**WEST SUSSEX COUNTY COUNCIL  
STRATEGIC PLANNING CONSULTATION**

**DATE: 13/05/2015**

**SUBJECT:** BE/60/15/PL-Demolition of existing dwelling & erection of 8 No. three bedroom dwellings with new access & car parking.

21, Bucksham Avenue, Bersted, West Sussex, PO21 5DT

PROPOSED SITE PLAN
(1:200)

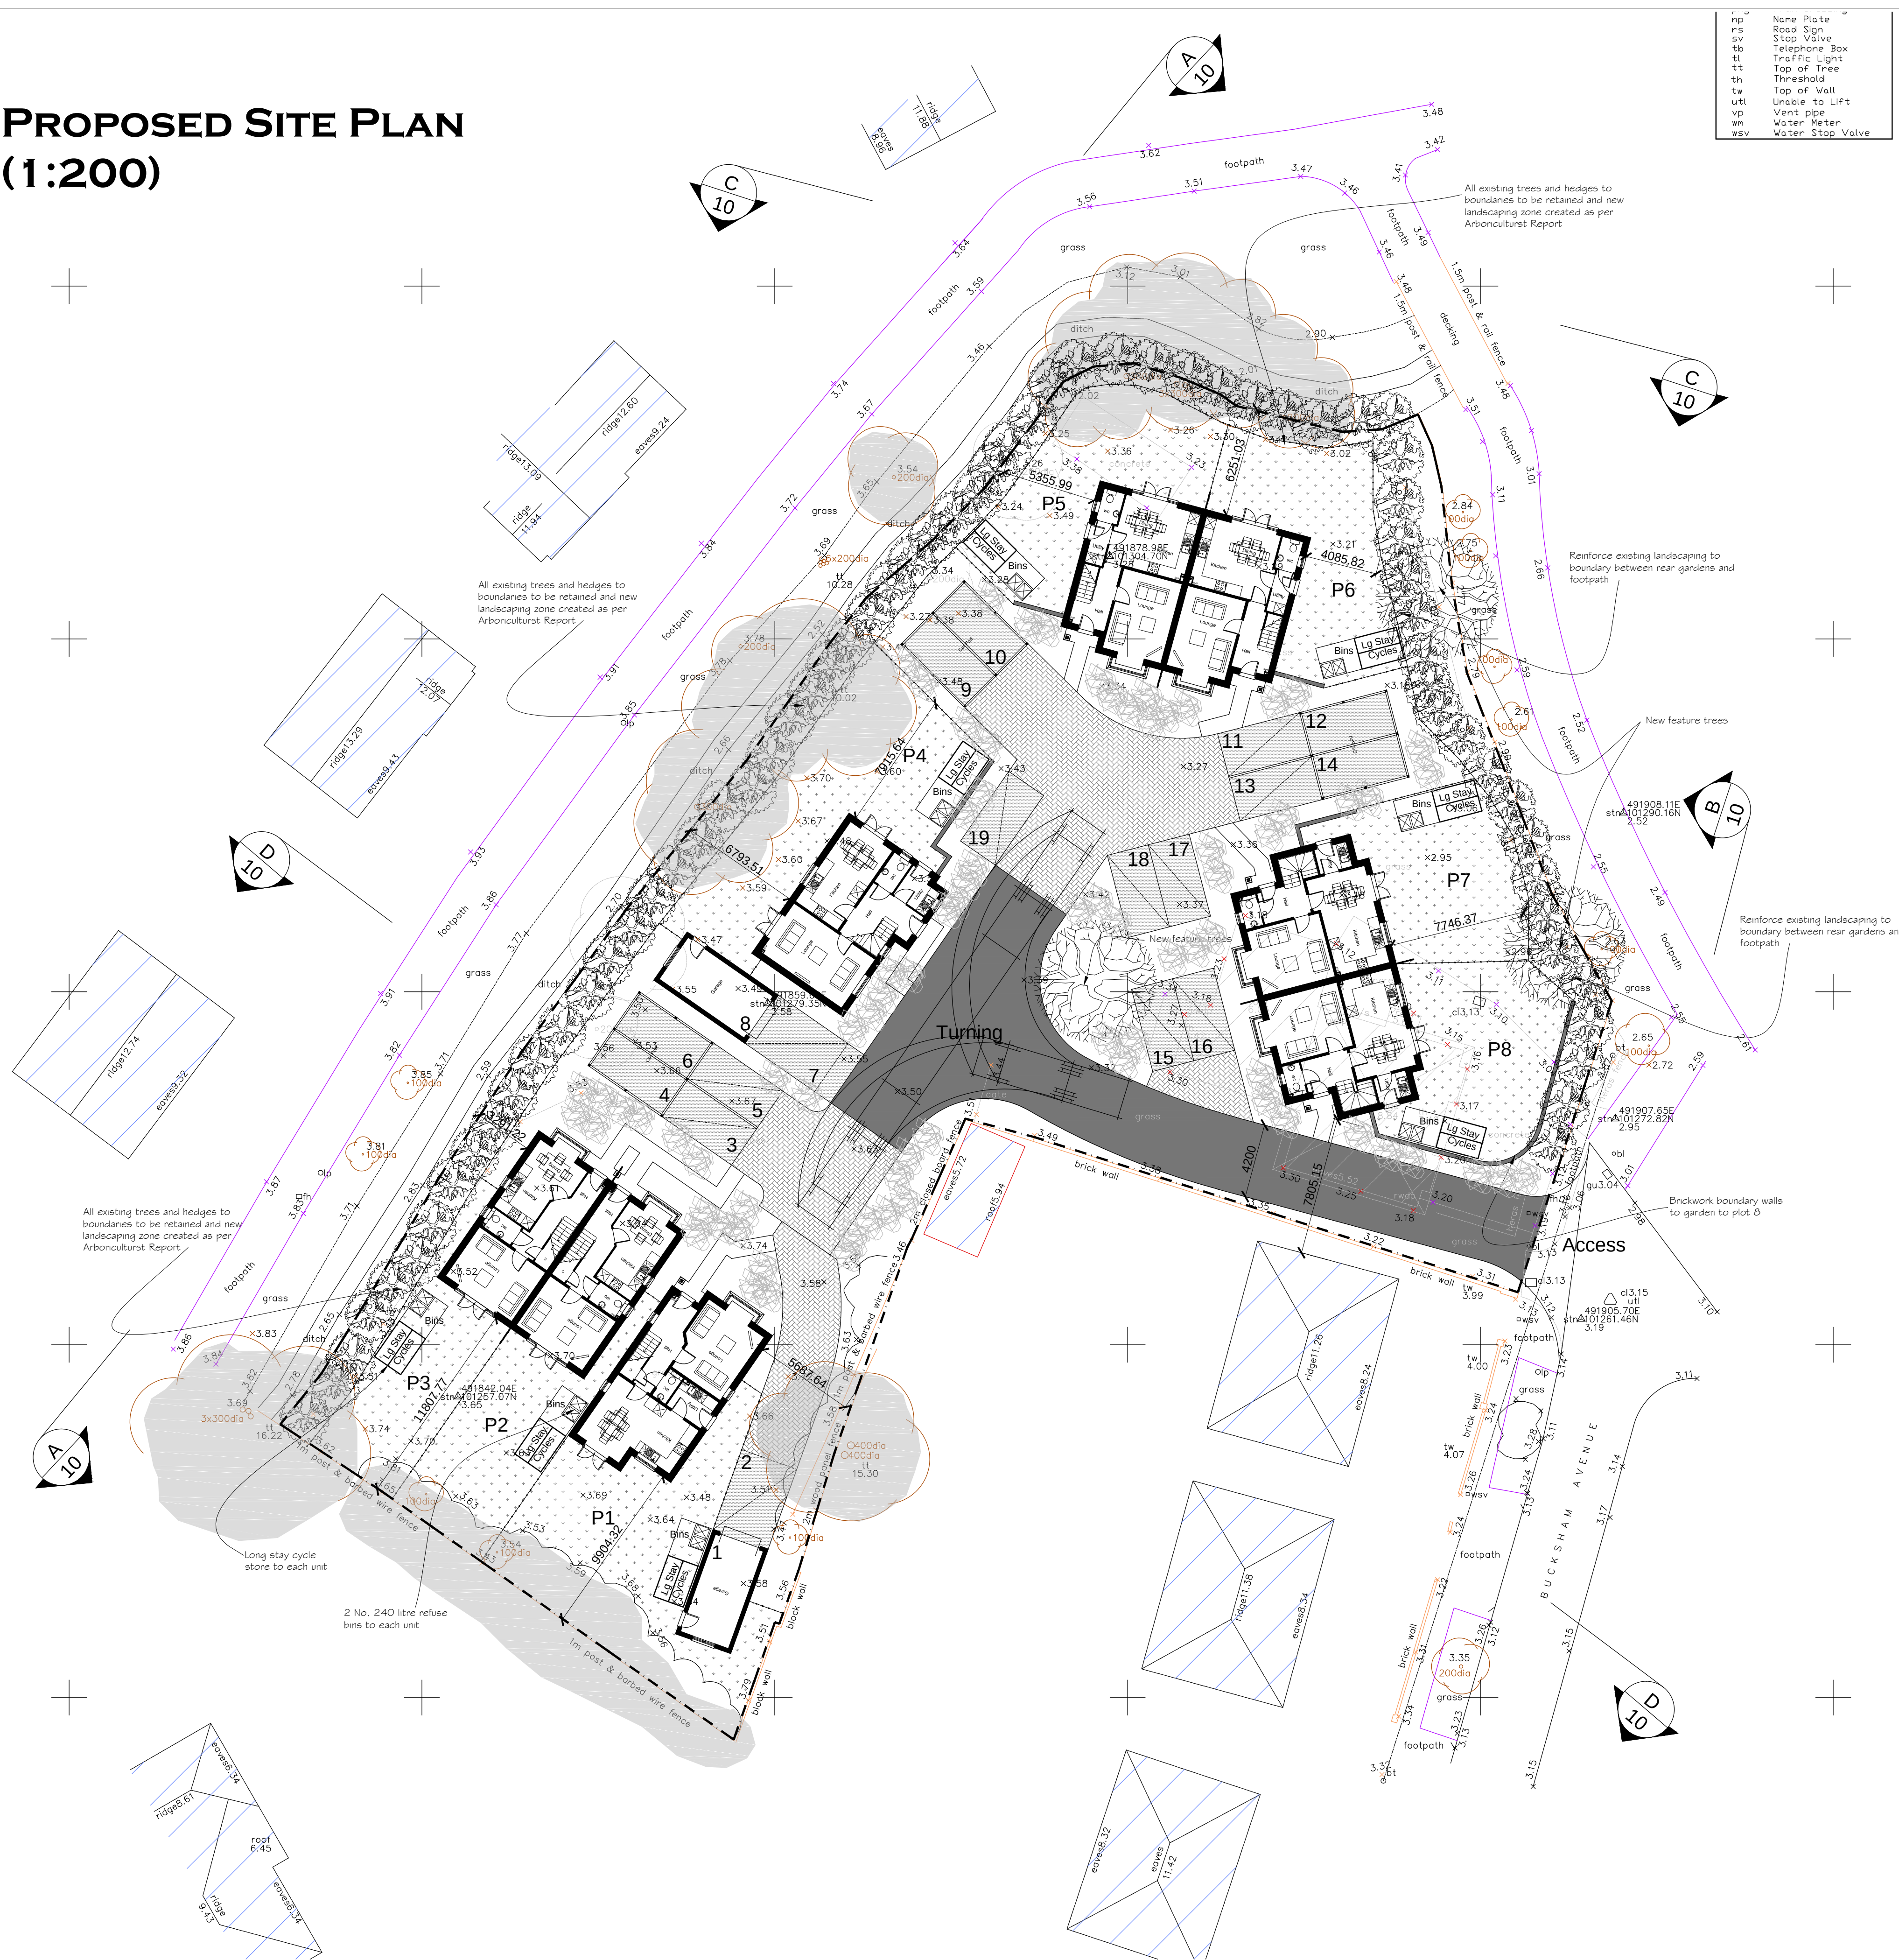
The site is situated to the north of Bognor Regis. The site is to be accessed via a new access onto Bucksham Avenue, which is a no through road and subject to a 30 mph speed limit. The access road will take the form of a 4.5 metre wide shared surface arrangement. This is considered suitable as this will be a low speed, low traffic environment. The proposed highway works should be undertaken with our Implementation Team under a Licence Agreement.

A total of 19 car parking spaces will be provided on site. This provision has been considered against the WSCC Parking Demand Calculator (PDC). The proposed provision does not exceed the requirement generated by way of the PDC. In terms of parking layout there is a suitable amount of hardstanding for vehicles par and manoeuvre within the site.

There has been no indication of whether refuse collection will take place from within the site or from the access point onto Bucksham Avenue. Therefore it is advised a communal bin store is placed at the access point onto Bucksham Avenue. The waste collection authority should be consulted to obtain their views on the suitability of this arrangement however. If a refuse vehicle is to enter the site a further plan showing via swept path diagrams should be provided demonstrating that a larger vehicle can manoeuvre within the site.
